Ref: 012150 - DES-Volkswagen Hatfield

RE: Planning Approval: **6/2020/3222/MAJ**
Location: Former Volkswagen Van Centre Comet Way Hatfield AL10 9TF
Development: Demolition of existing buildings and construction of new building comprising 118 residential apartments, layout of parking areas, landscaping, electricity substation and ancillary development
Non Material Amendment

**5F. FIFTH FLOOR LANDSCAPE**  
 1 : 75

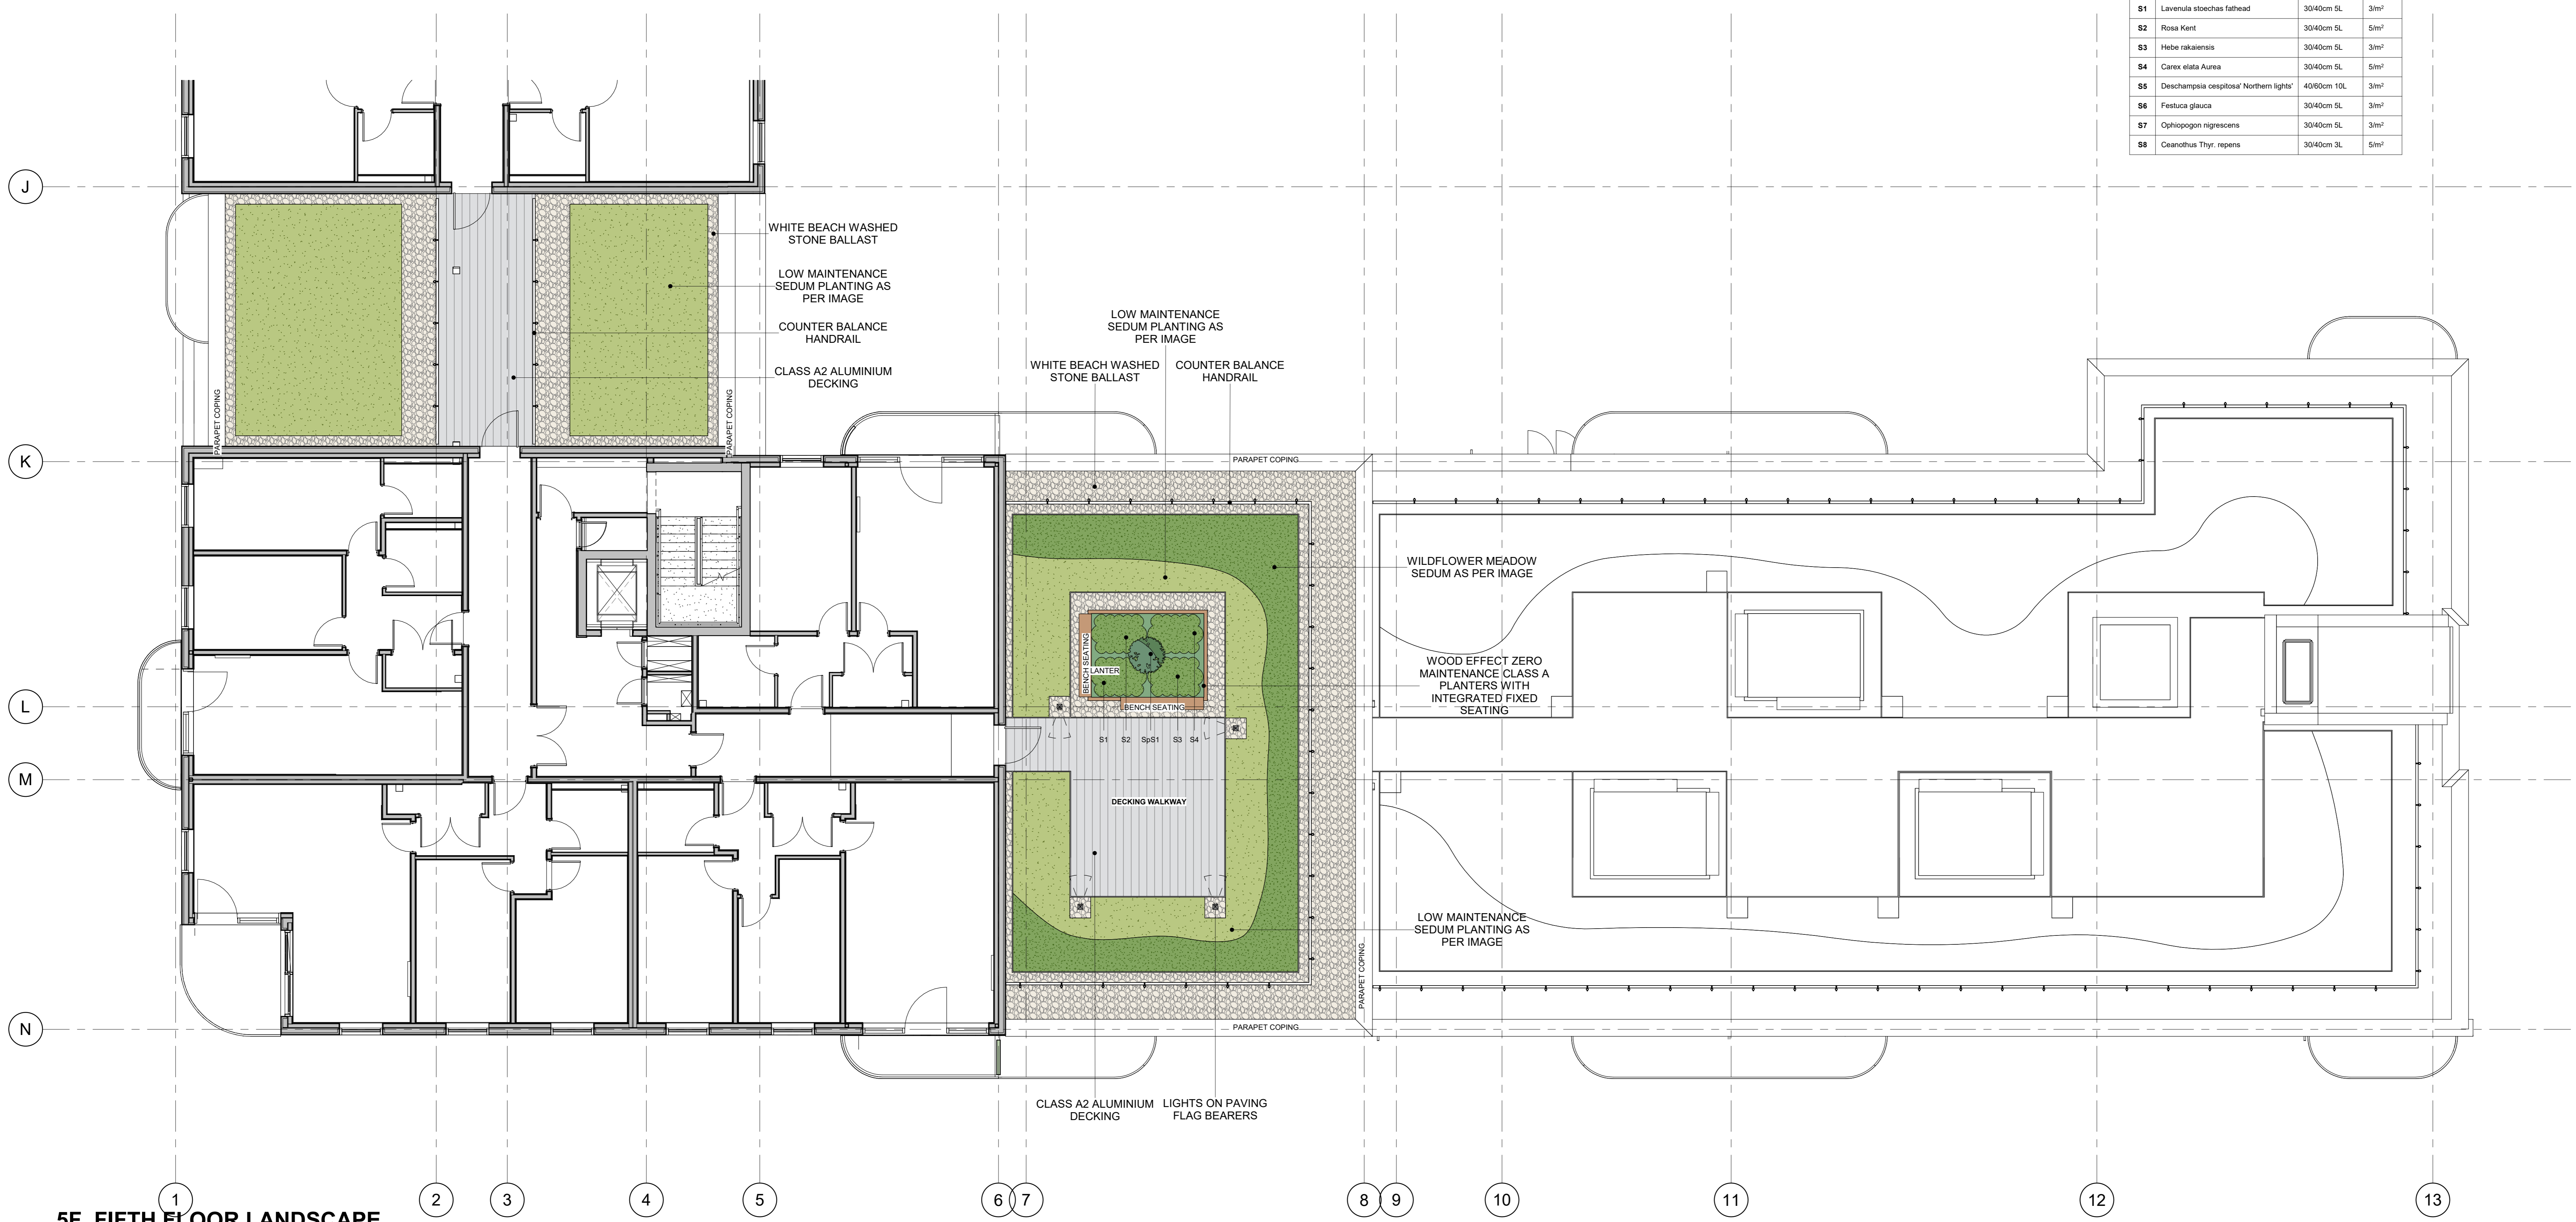
Terraces are very important spaces and the original palette of landscape plants we have kept as per the original drawings within reason prepared by Briarwood Landscape Architecture. There is a very serious safety concern having the planters placed right beside the roof balustrades and there is too much of a temptation for any person to deliberately climb over the guarding. The risk has been eliminated from the new proposal by reorganising the landscaping to push the planters away from the edge. All decking on the roof we are proposing in A2 rated aluminium type again for fire safety reasons. Tall trees are not permitted on top of the roof surface because of the weight which causes stress loads on the roof structure in particular as root balls tend to absorb more water. We are limited to 0.5 kN/m² dead load on the roof. This means in prefer the use of the plants and shrubs per the original design intent but not the trees. New trees are places on ground level as best practical to avoid the positions of key underground services we have found by survey scan.

1. SOUTHEAST TRUE ELEVATION (COMET WAY)

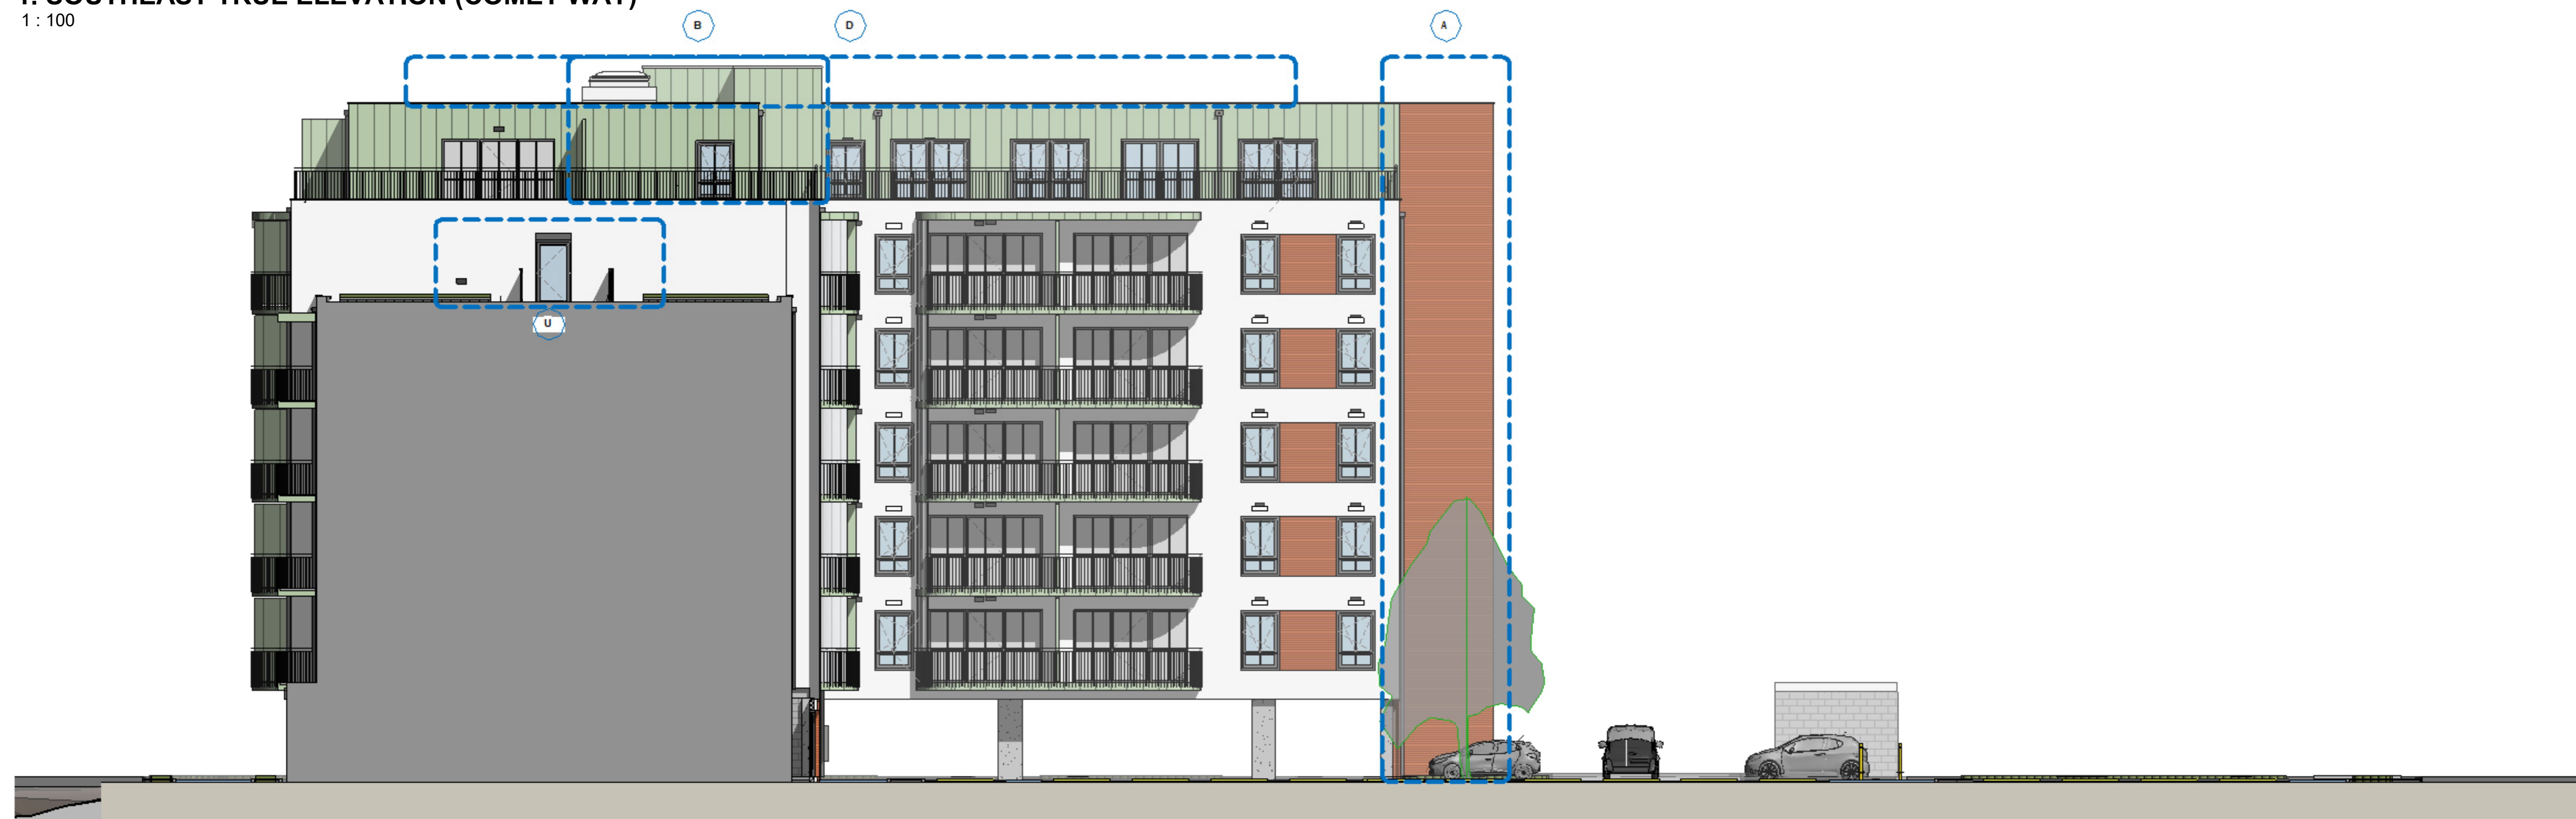
In general, the façades are in principle the same as those submitted for approval. We have added a sloped roof enclosure to the fire escape off the roof terrace as fire escape routes are required to be covered when used for a fire escape stairs, preventing snow build up blocking these stairs. One other minor element is that we would like to change the terrace protection guarding to a more robust vertical metal guarding. In the previous application this is in glass, however there is a strong potential for breakage accidentally or deliberately by anti-social activity and once the glass breaks there is a definite breach point for a person to fall from the building. It is a health and safety risk for the building.

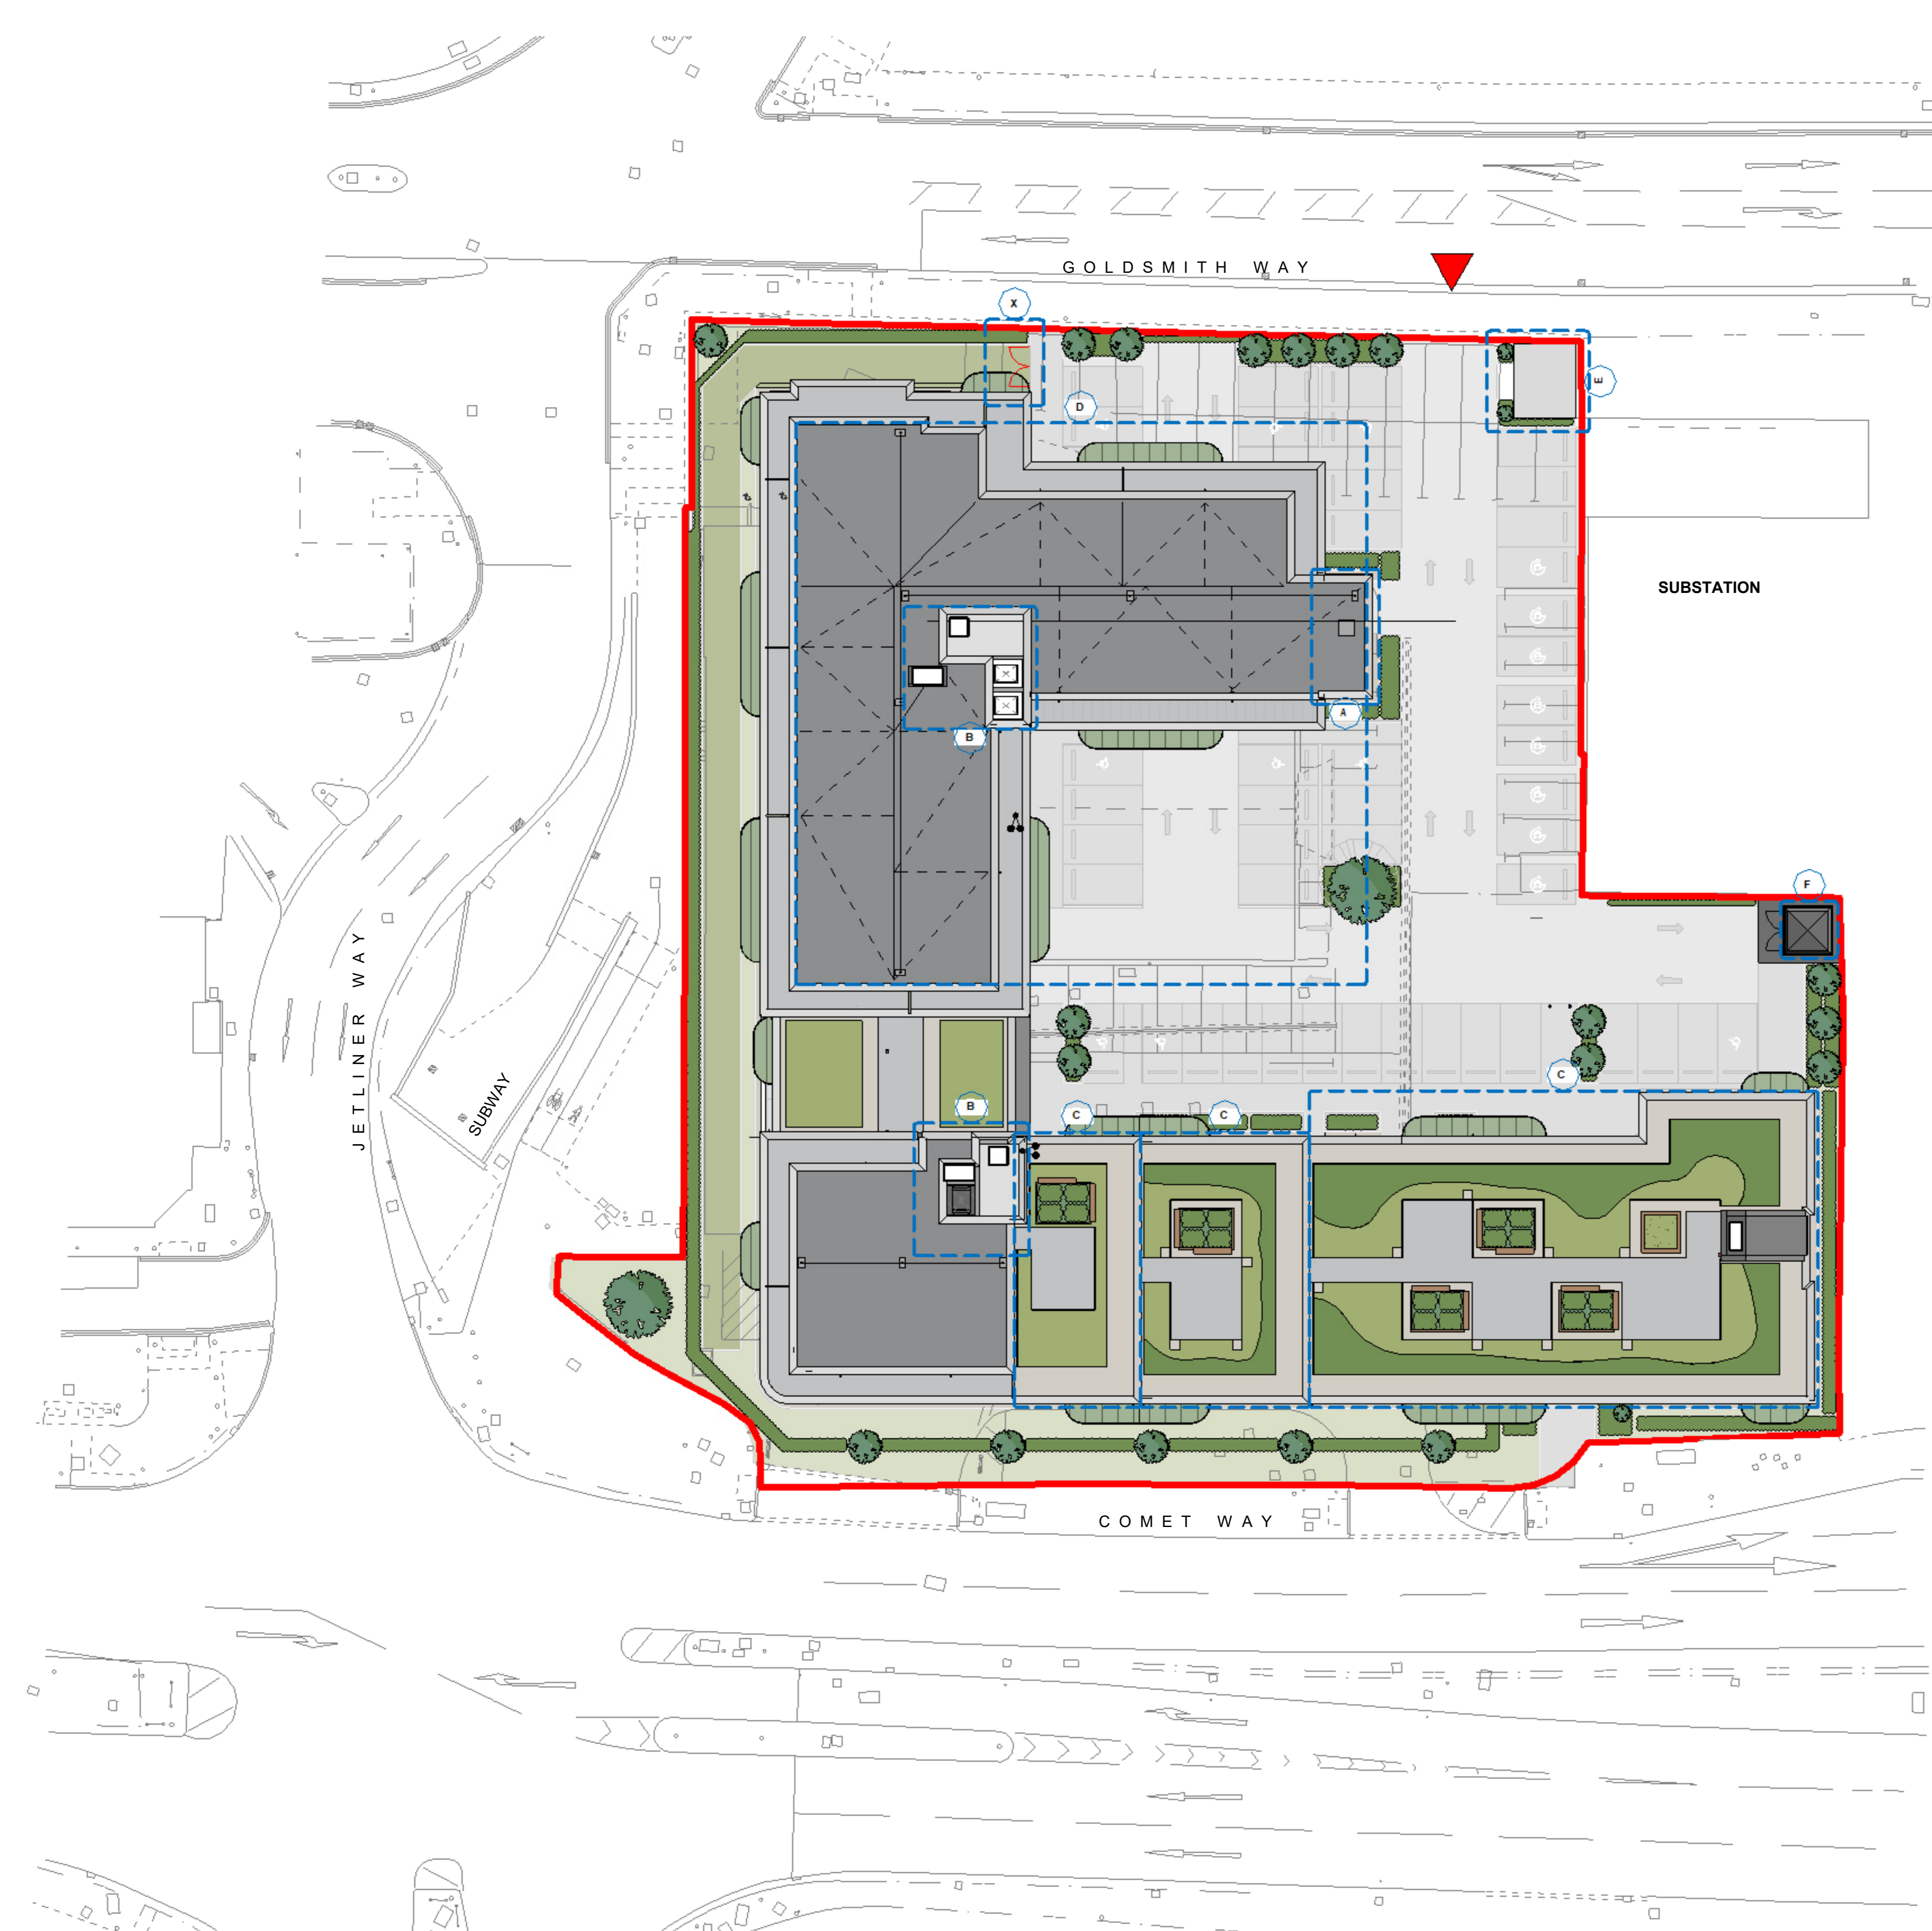
On the roof level, there are a number of photo voltaic installations shown on the original planning application roof. Having carried out multiple SAP assessment energy performance calculations, the use of PV on the roof is not sufficient to serve the building needs as there was less than half of the required roof surface needed that would have been required to serve the building. Thus, we are omitting the PV for the purposes that is not practical nor efficient and instead we are proposing for individual apartment basement whole unit ventilation system MVHR (mechanical ventilation with heat recovery)
